Subject: FW: Beach shelter Toilets - Planning application LU/307/17/PL

Subject: RE: Beach shelter Toilets - Planning application LU/307/17/PL

Ground floor plan | proposed

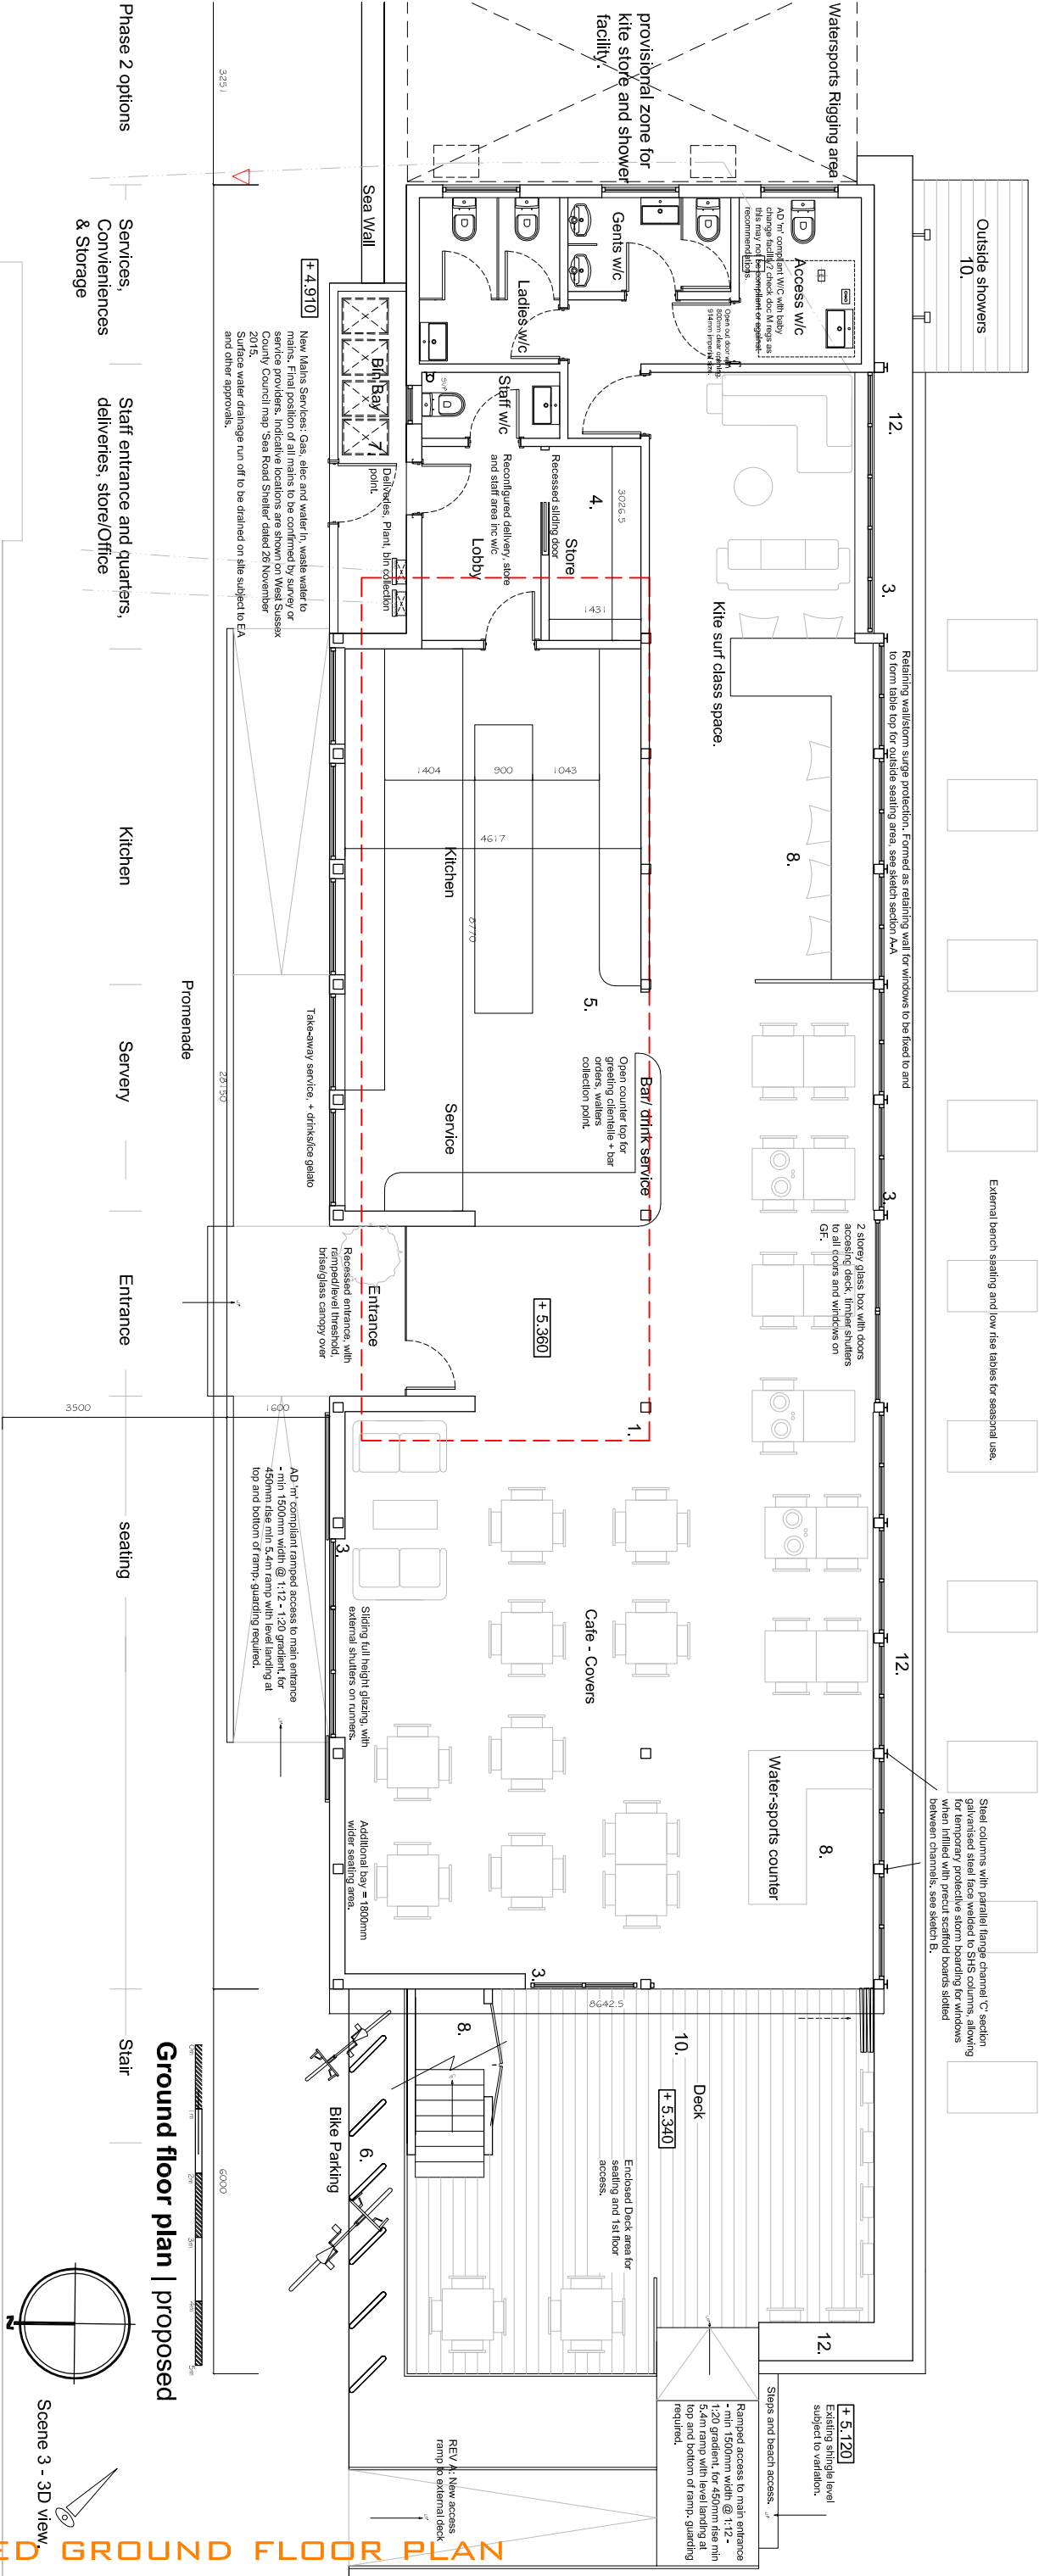
Having reviewed the plans with Phil Graham I can confirm that providing the number of customers is limited to a maximum of 200 then the proposals set out for the sanitary convenience are adequate, i.e. 2 female WC's with wash hand basins, 1 male wc and 2 urinals with wash hand basins and 1 unisex wc with wash hand basin.

I can confirm for the record that there will not be more than 200 seats in the development. Thankyou for your assistance in this matter.
